RESPONSE TO SUBMISSIONS REPORT

The New Primary School in Mulgoa Rise - SSD-11070211

17 November 2021

Drawing Reference
L-SSDA- 0014

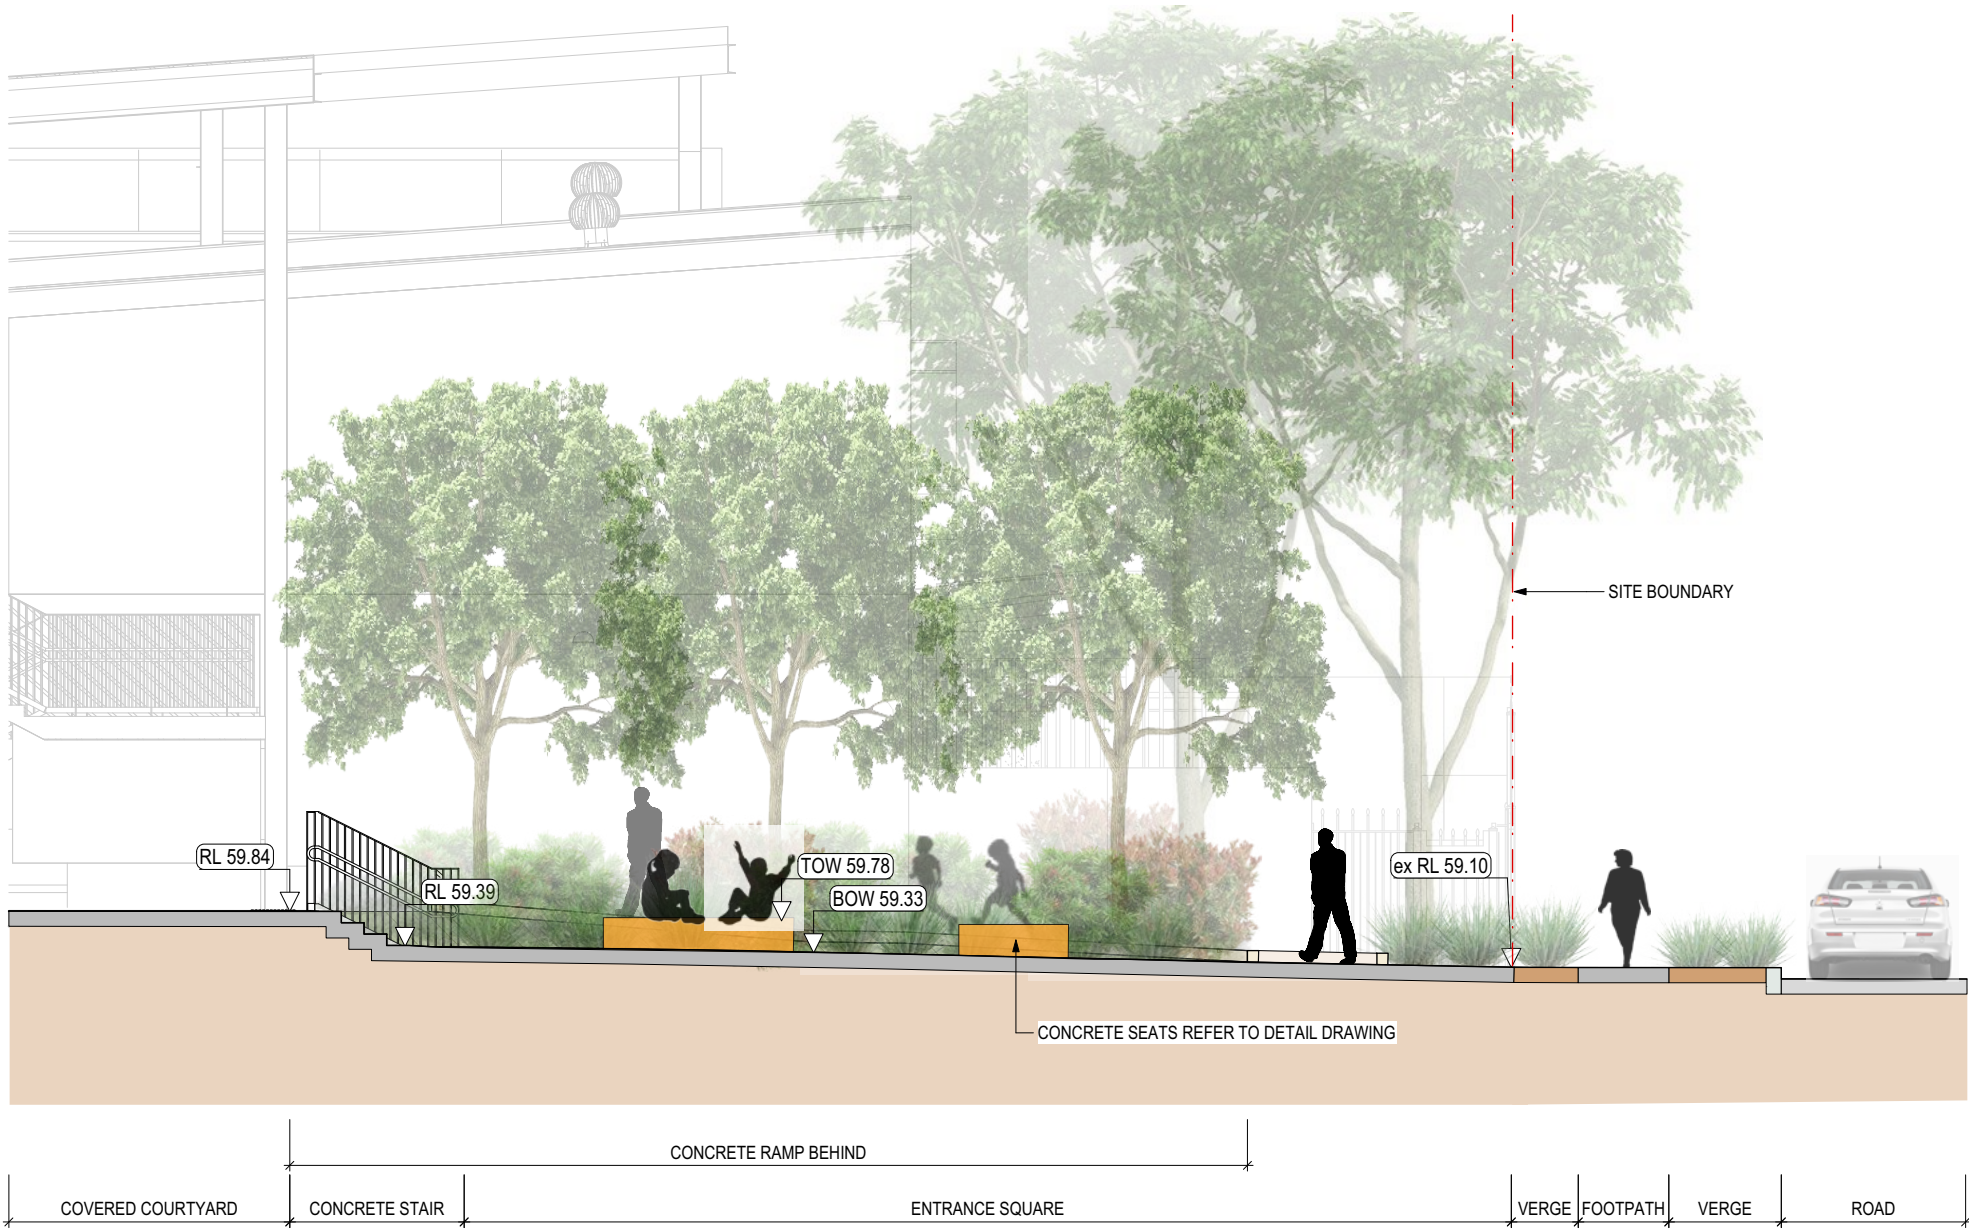
An extract from a Landscape Elevation illustrating the landscaping treatment that will be implemented on Deerubbin Drive at the interface with the entry to the waste area is provided in the figure in the adjacent column.

Extensive landscaping is proposed along the Deerubbin Drive interface with the proposed waste area.

The Landscape Elevation can be found in **Appendix C**.
